20 August 2021

File No: 2021/368689
Our Ref: R/2019/26/C

Supplementary Response to Submissions – Atlassian Office and Hostel Development – SSD 10405

DRAWING
SHED - SOUTHERN
ELEVATION
DOCUMENT NUMBER
DA-11C-GXX-02
ISSUE
6

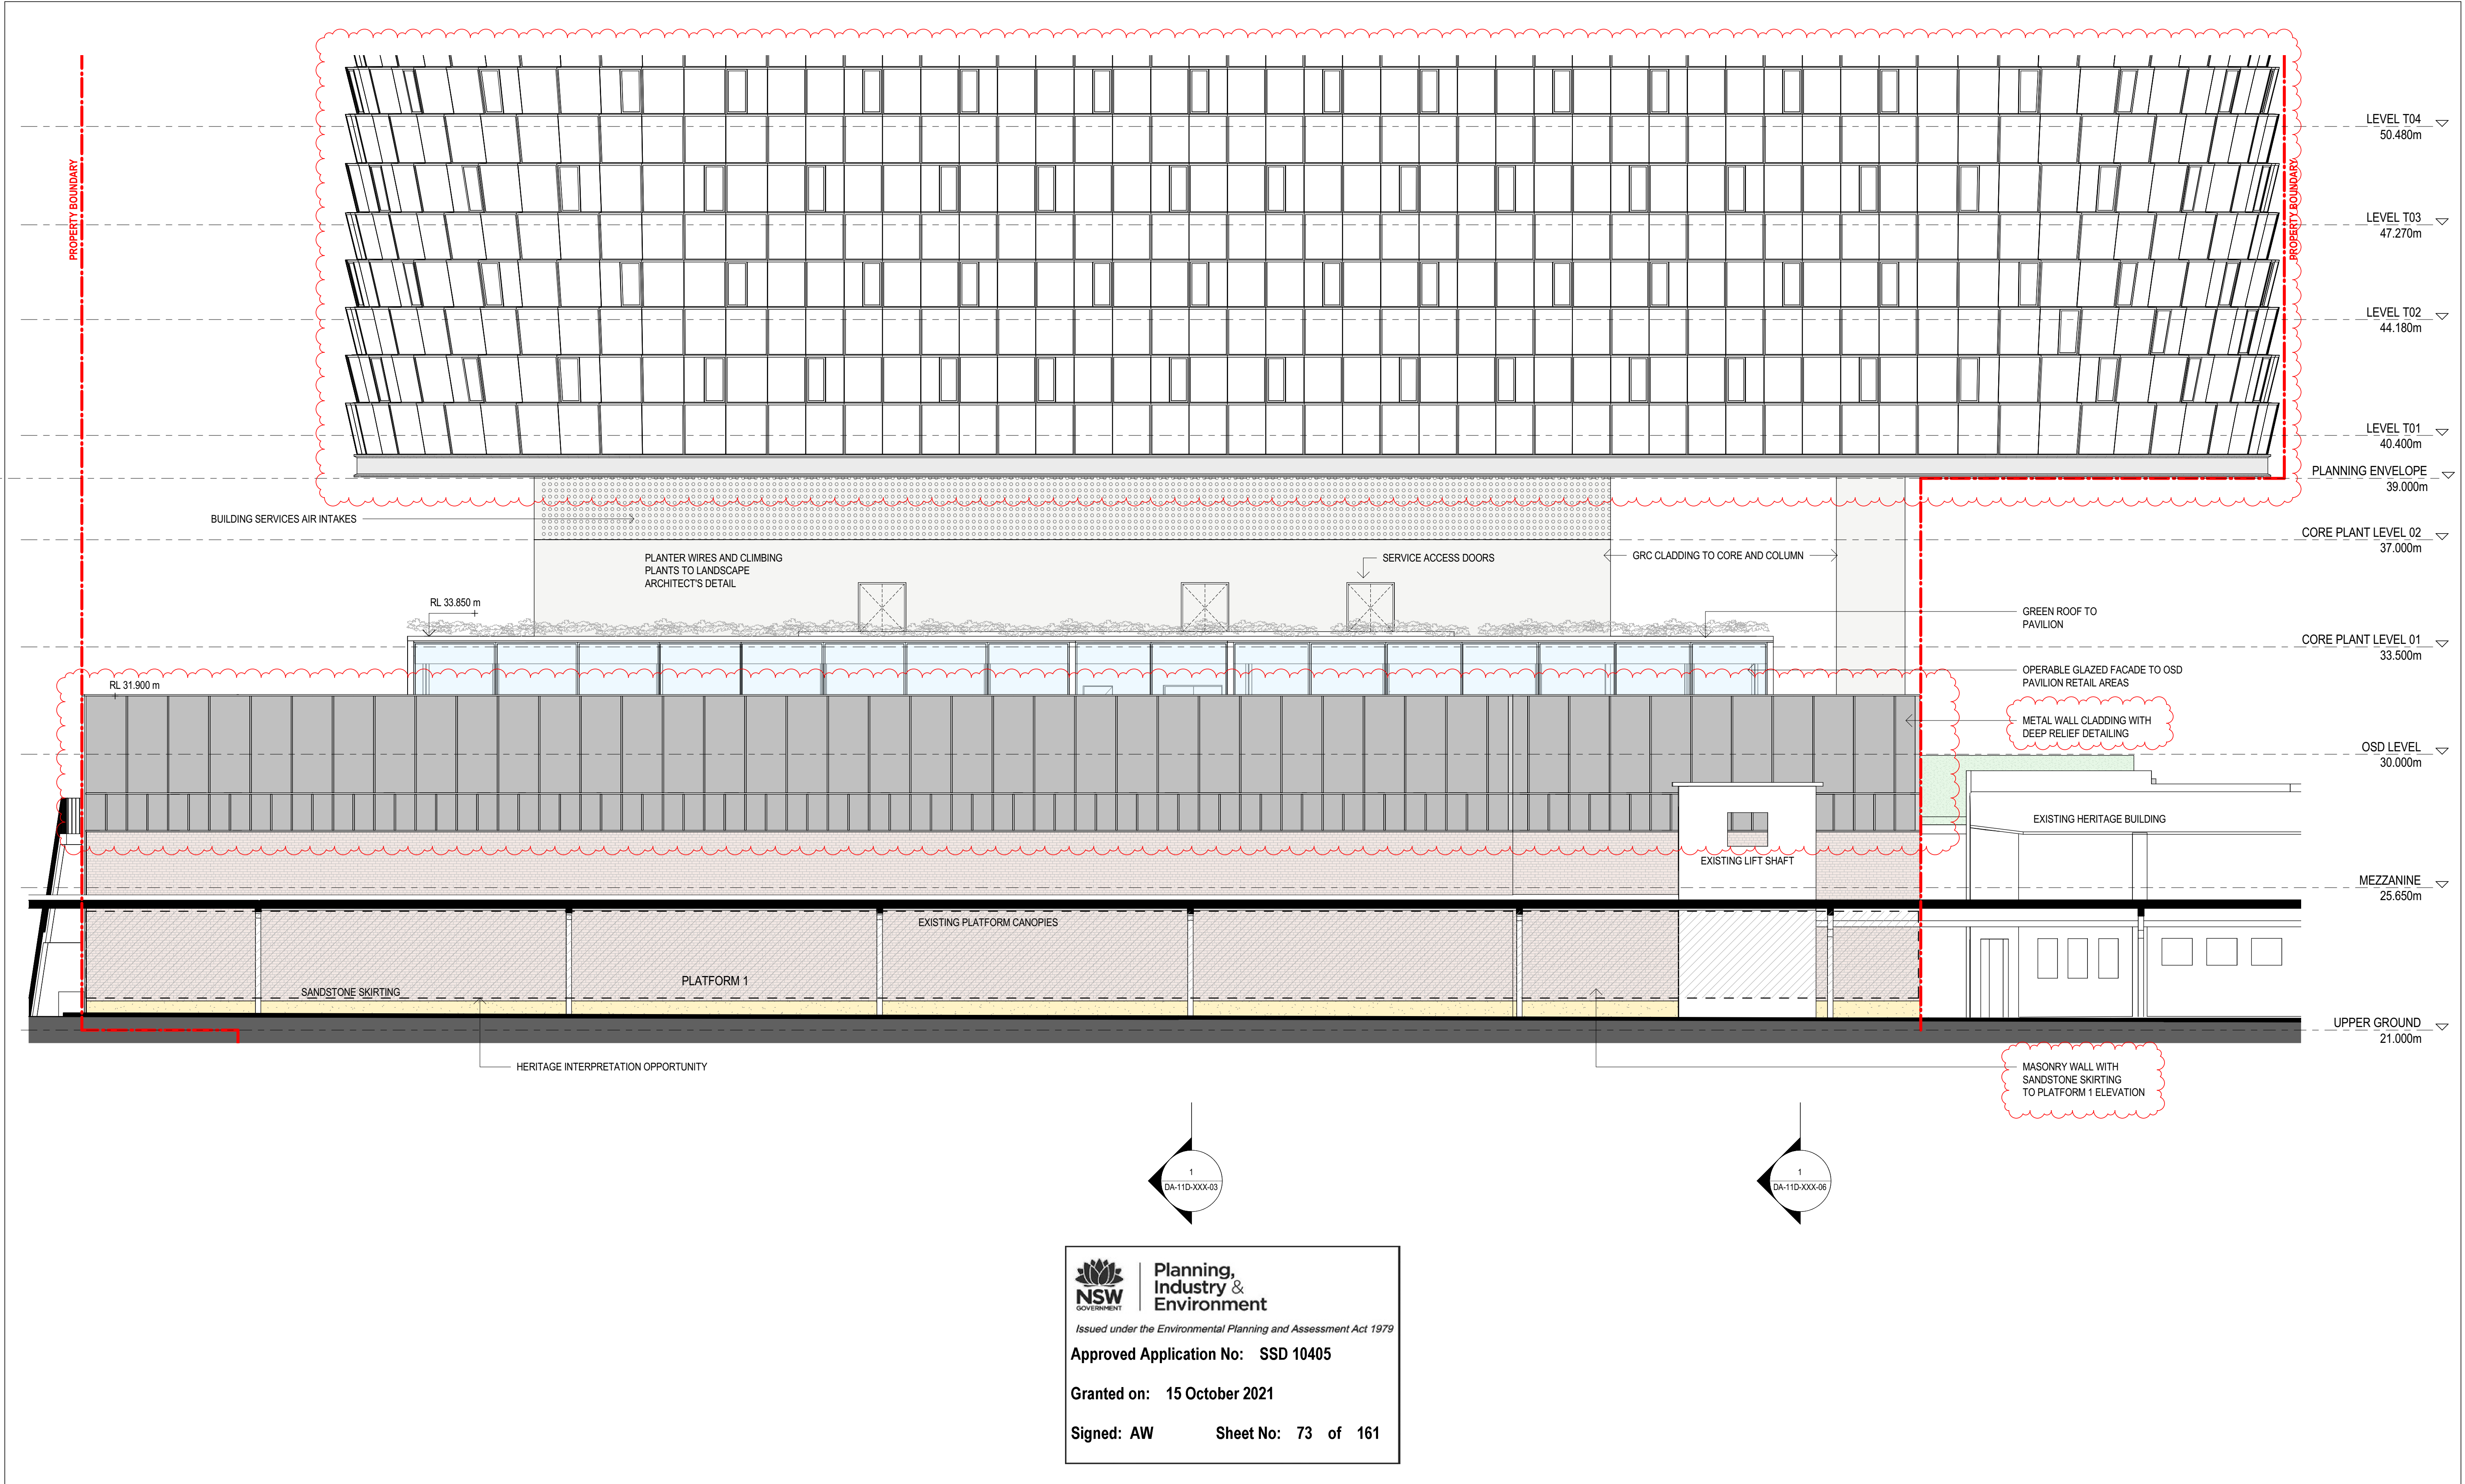
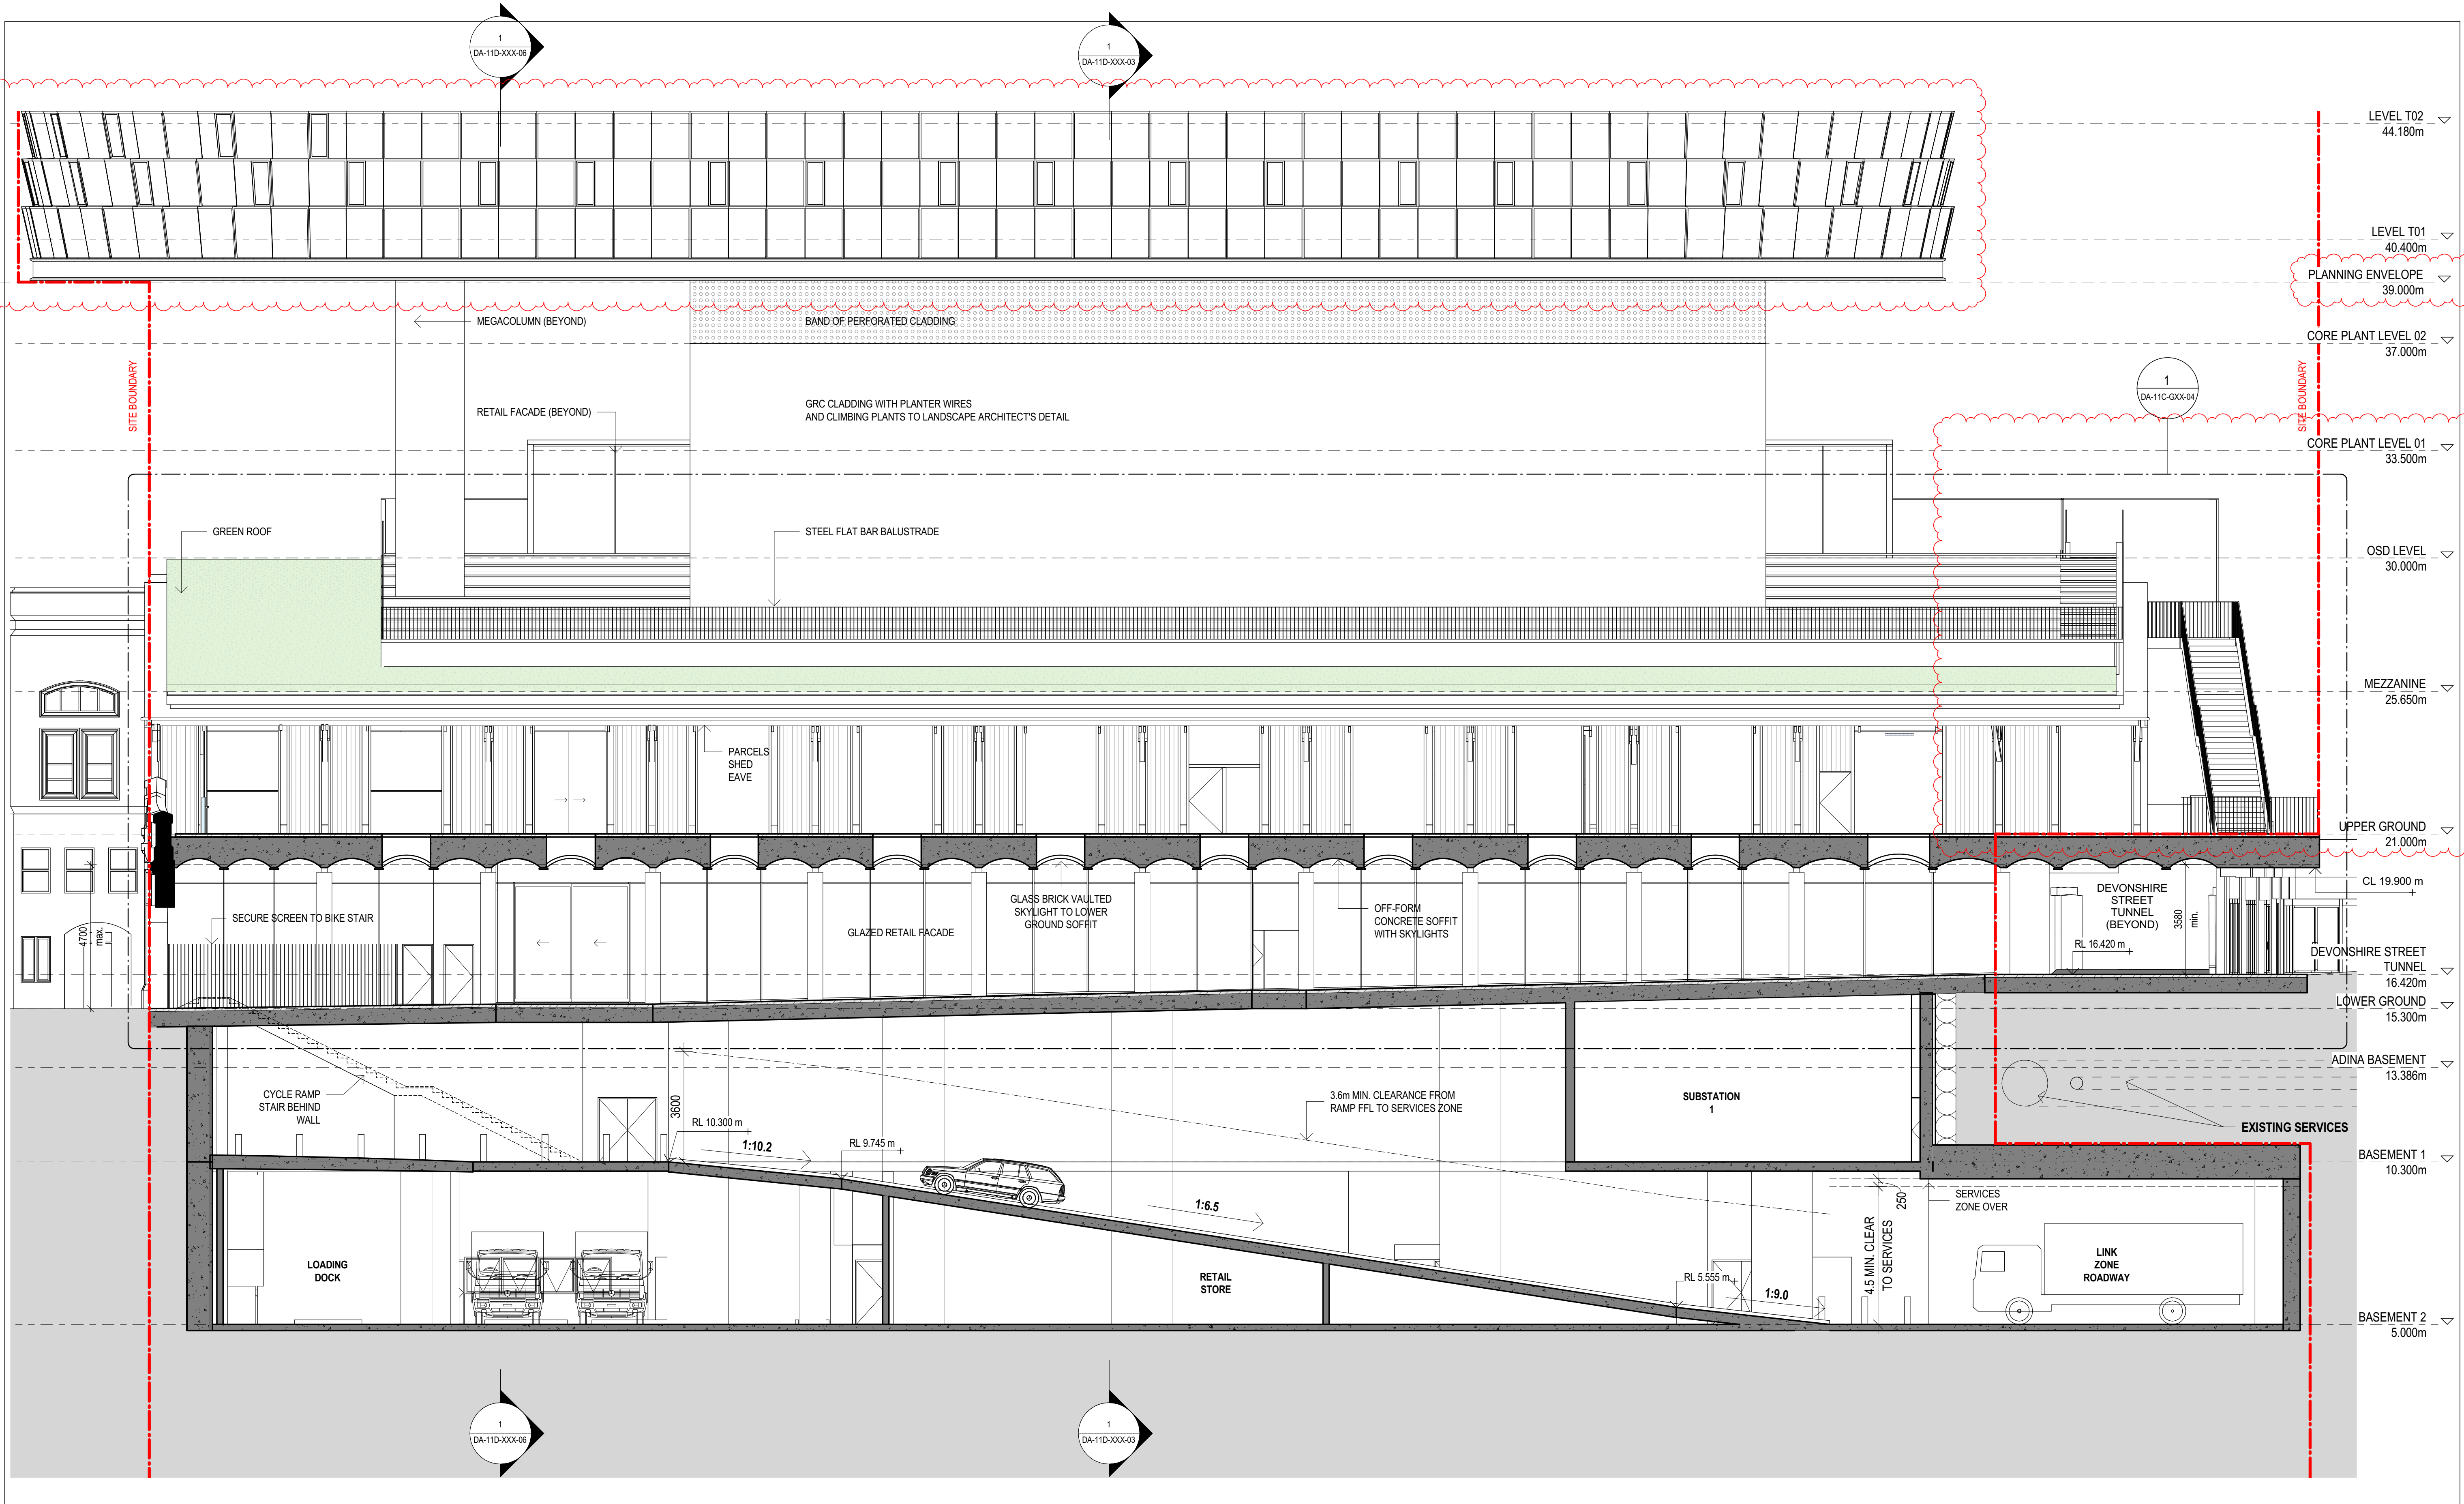
3. The City maintains its objections to the structure and treatment above the state listed heritage shed roof, and request that this unnecessary element is deleted from the plans. Some minimal structure may be appropriate subject to consultation with the City and Heritage NSW to achieve fire egress where there is no alternative route of escape.
4. However, if DPIE concludes to approve this arrangement, the City requests that the applicant's proposed design modification condition is amended as follows:

(a) Design modification must, where possible, preference the retention **and visibility** of heritage fabric ~~and the ability to perceive~~ of the inwards parcels shed roof form **by maximising the metal roof sheet exposure to a minimum 1.5 metres from the north, south and west edges of the roof.**

5. The City commends the applicant's commitment to incorporate Designing with Country within the development, however, as previously stated the shed roof overlay is a poor solution.

Prior to the release of the Construction Certificate for Stage 6 the design of the ~~western component of the~~ former inwards parcels shed roof (as identified on DA-

10B-G03-01) is to be modified. The following matters are to be taken into consideration.
